Current Zoning: N1-A (neighborhood 1-A), RE-3(CD) (research, conditional), OFC (office), CG (general commercial), B-1(CD) (neighborhood business, conditional)
Proposed Zoning: UR-2(CD) (urban residential, conditional)

Approximately 33.03 acres located along the west side of John Adams Road, south side of Galloway Road, north of West Mallard Creek Church Road, and east of Interstate 85.

The petition proposes to develop a residential community containing a maximum of 345 single-family attached dwelling units in a townhouse style.

REZONING SITE PLAN

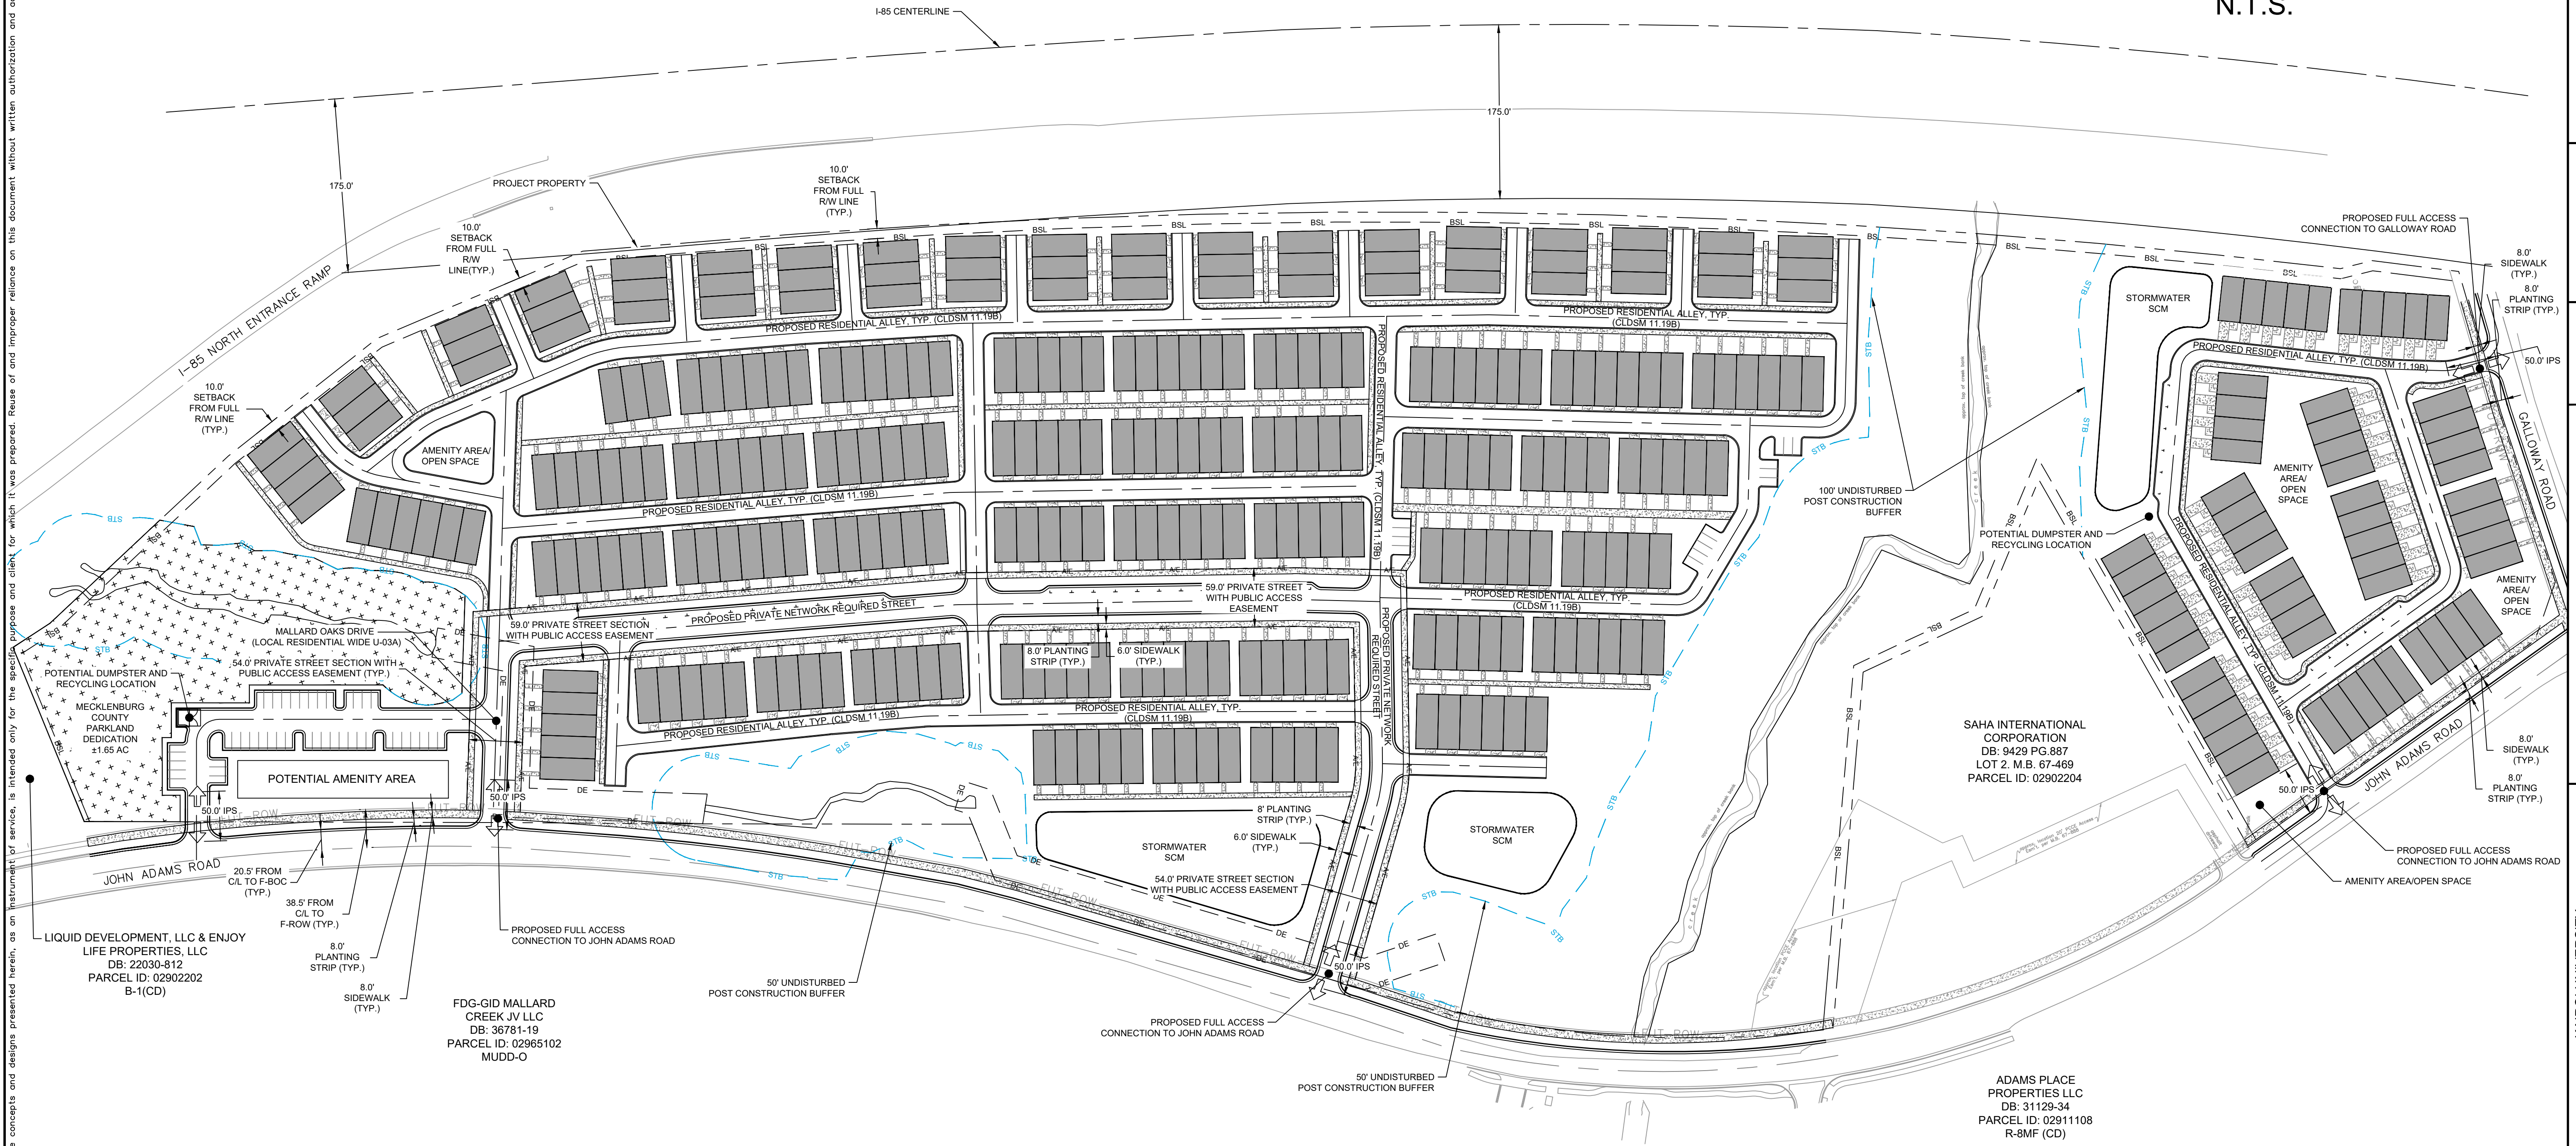
1. ~~Consider relocating amenity area to a more central location within the site.~~ Addressed
2. ~~Show visitor parking for the Galloway Road section of the development.~~ Addressed
3. ~~Show dumpster and recycling location for the Galloway Road Section of the development.~~ Addressed
4. ~~Consider connecting the John Adams portion of the site to the Galloway Road portion via a walking trail.~~ Addressed
5. ~~Consider breaking up the 6-unit buildings into 4-unit buildings.~~ Addressed
